Application no: H15-0941-09

Description: Details of bricks and panel showing mortar mix, extent of brickwork repairs and support structure to gable wall and alternative constructional details for cast iron sash weights and traditional cill (Conditions 2, 3, 4 and 6 of H15-0938-08)

Amendment: Revised sash window detail, gable support and floor joist calculations (dwg. no.W1C)

-----Original Message-----
From: Crew, Chris [mailto:ccrew@sholland.gov.uk]
Sent: 05 January 2010 15:01
To: Chris
Subject: Bresby House condition compliance application - H15-0941-09

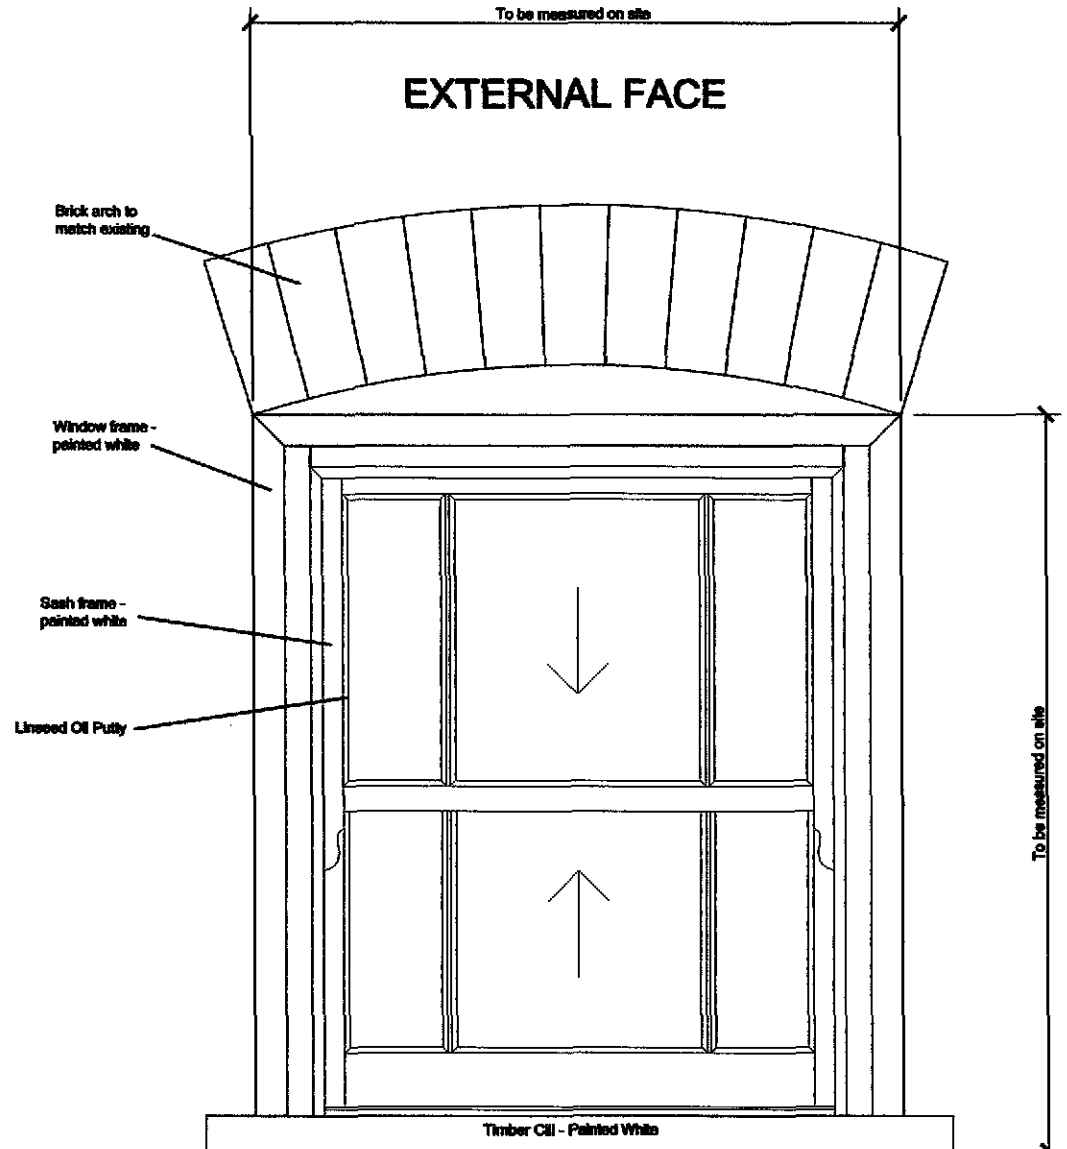
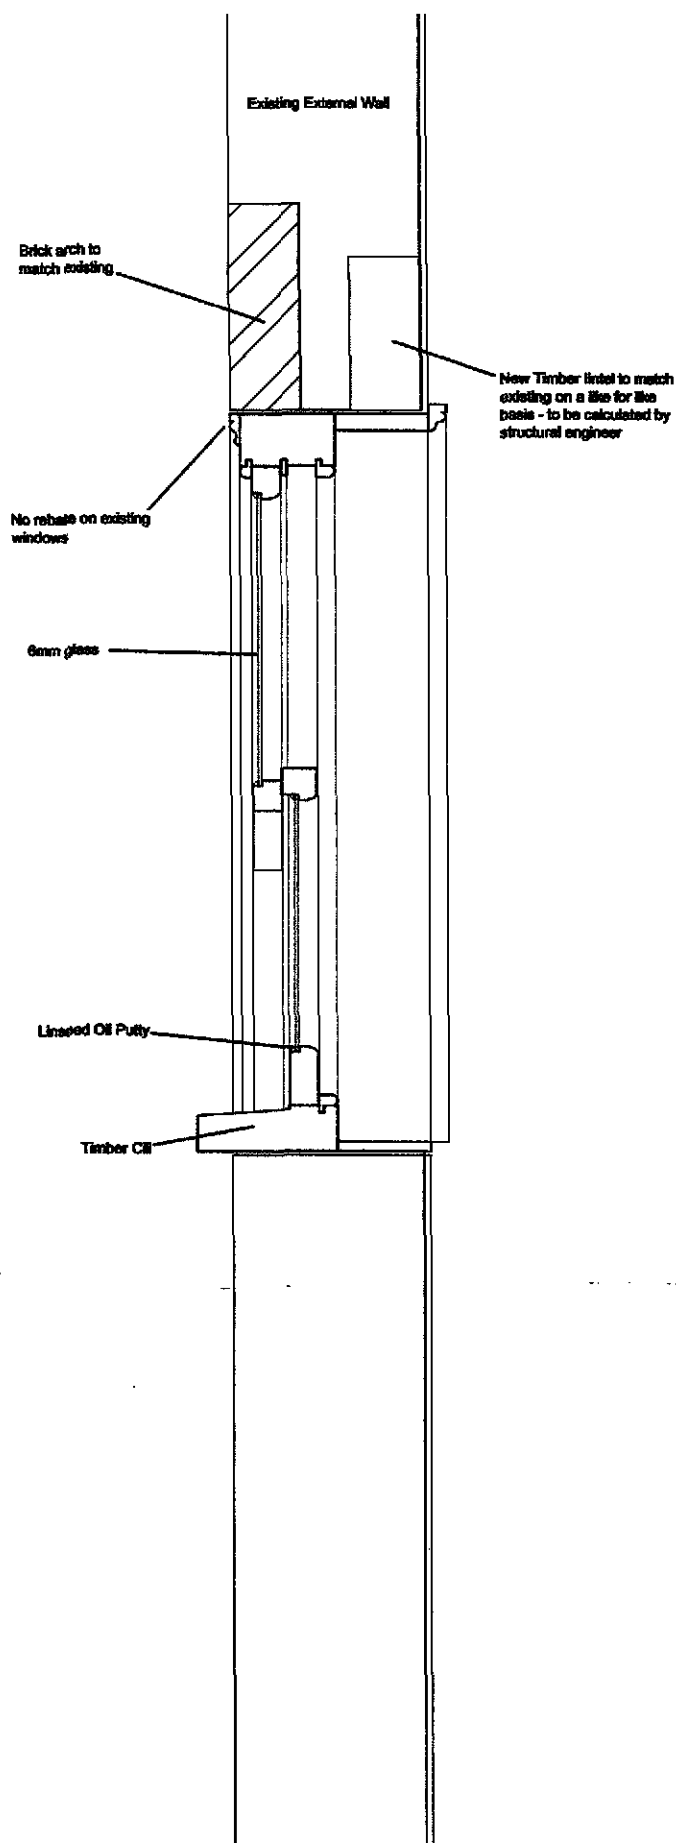
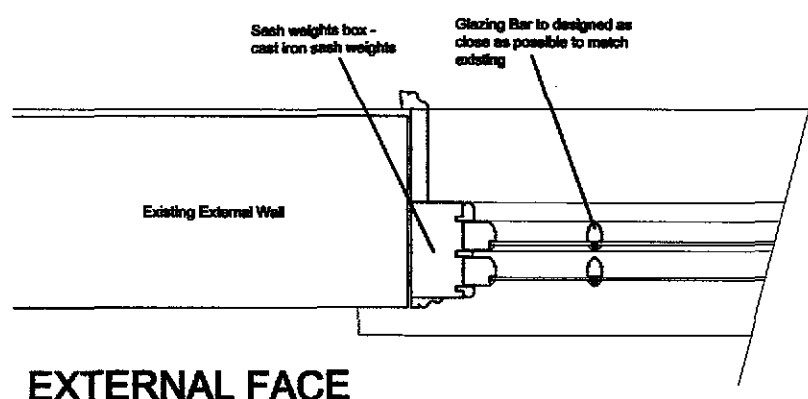
- I'm slightly concerned by the woolly detail on the window drawing- the external masonry is being rebuilt to match the existing opening, and it is the existing opening rather than the rebuilt section of wall that is the driver here.

The note on drawing 07099/W1C has been revised to read existing window dimensions are to be checked on site by the joinery manufacturer and matched; the note also states window ironmongery to be installed.

Project: Conservation Roof Lights & Structural Remedial Works
Bresby House, Quadding Easdele
Date: November 2009
Drawn: JM CL
Check: JM CL
Date: 07/09
Scale: 1:25 on A1
1:50 on A3
05/2 E

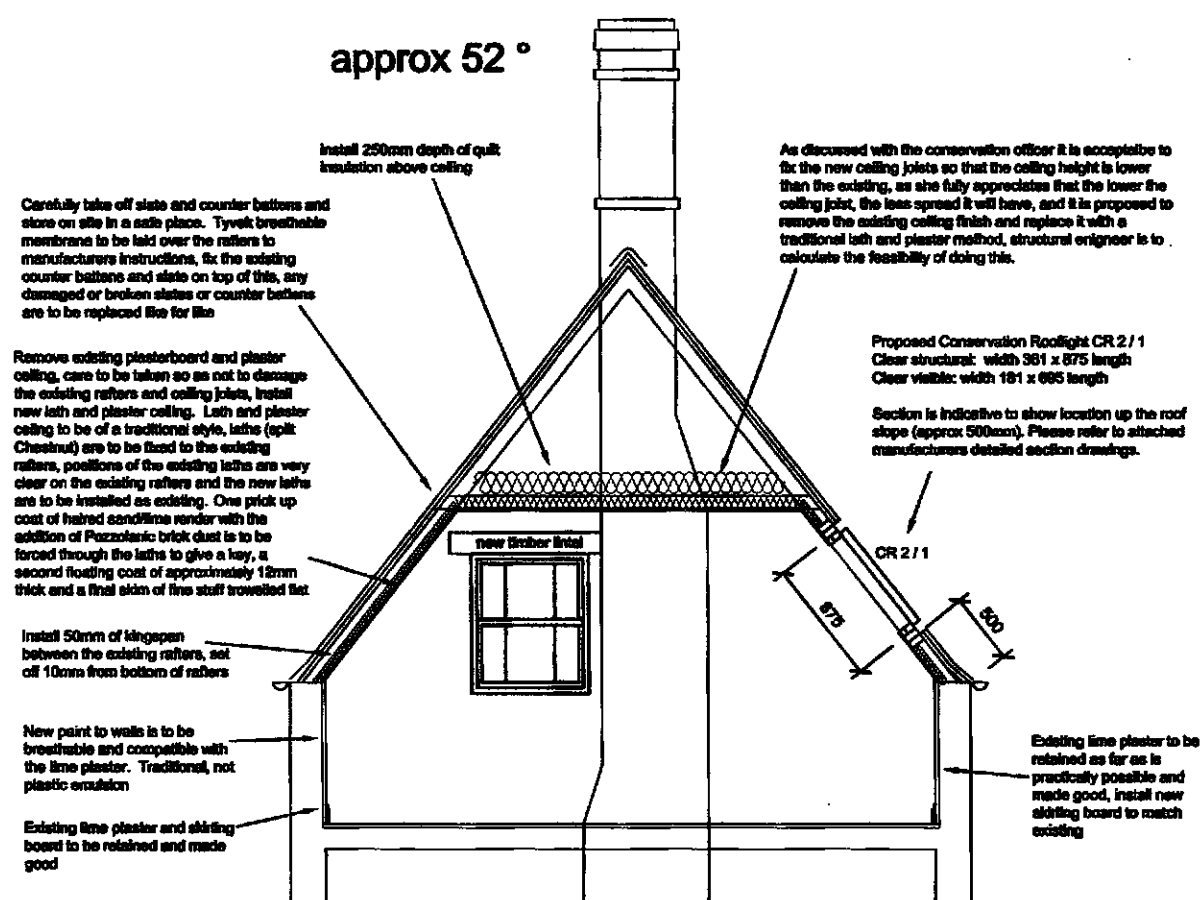
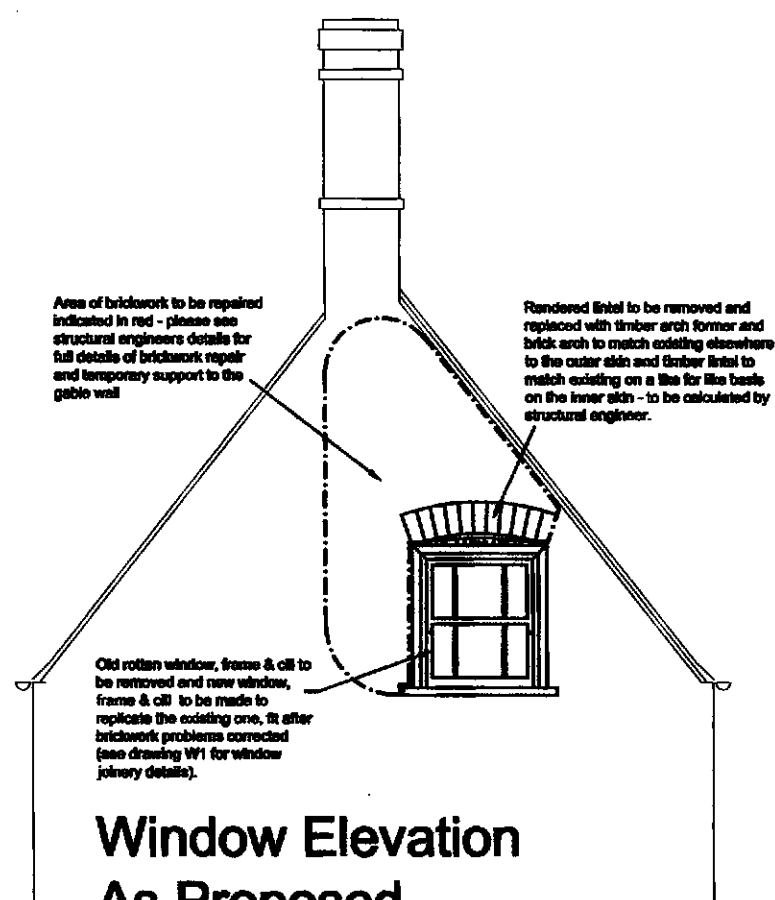
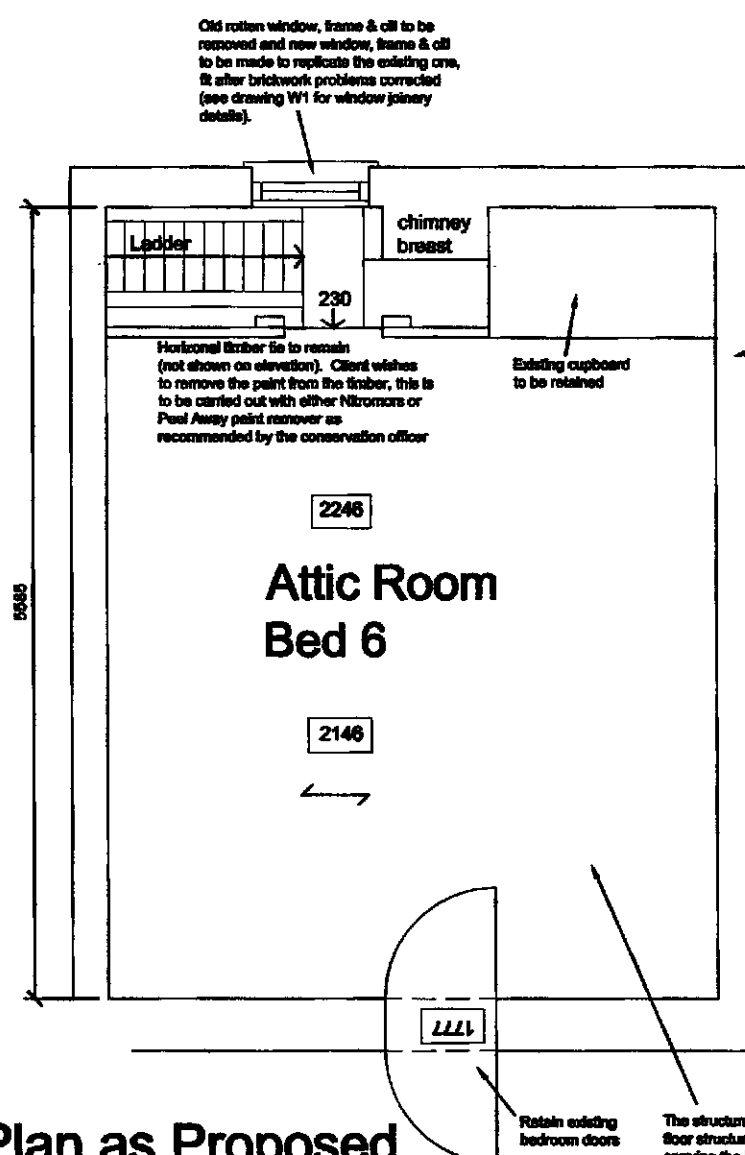
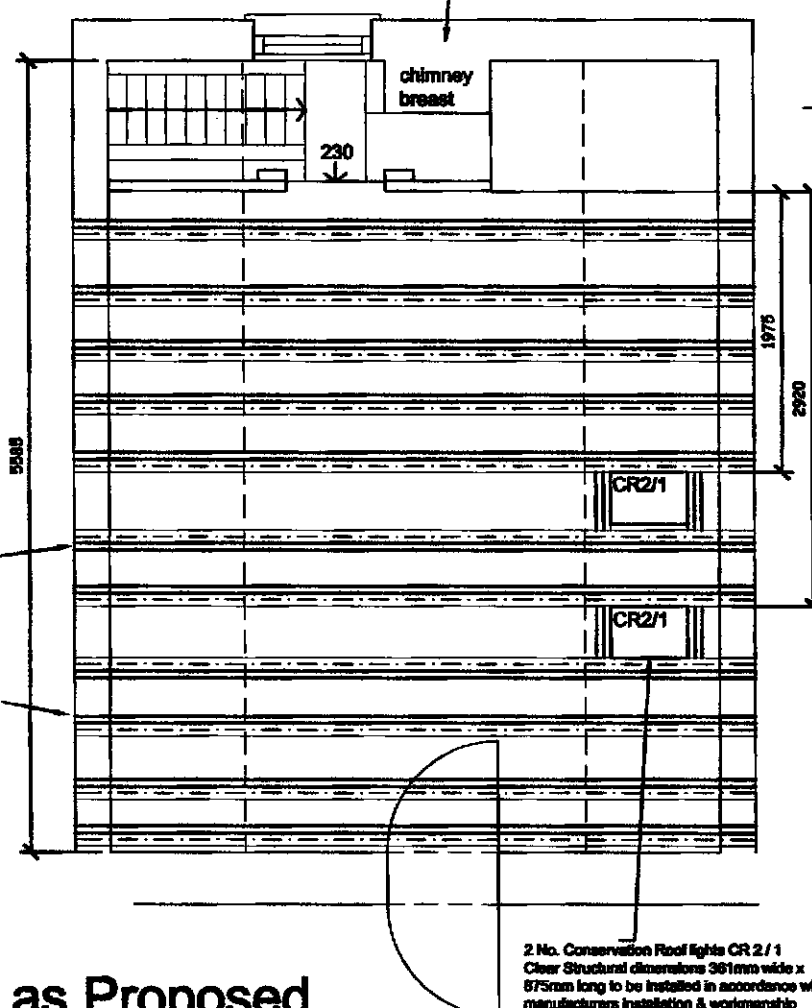
- The S.E.'s proposal to strengthen the first floor structure may be acceptable, but from the information provided it appears that the floor level of the first floor room will be raised to take account of the greater depth of the new joists. What impact will this have in terms of the floor structures relationship to the existing staircase, skirtings, cupboard and bedroom door?

The engineer has revised the strengthening to the floor joists. The joist depth has been reduced from 175mm to 100mm to match the depth of the existing joists, this means that the floor joist strengthening will have no impact on the relationship between the floor and staircase, skirtings, cupboards and bedroom door.
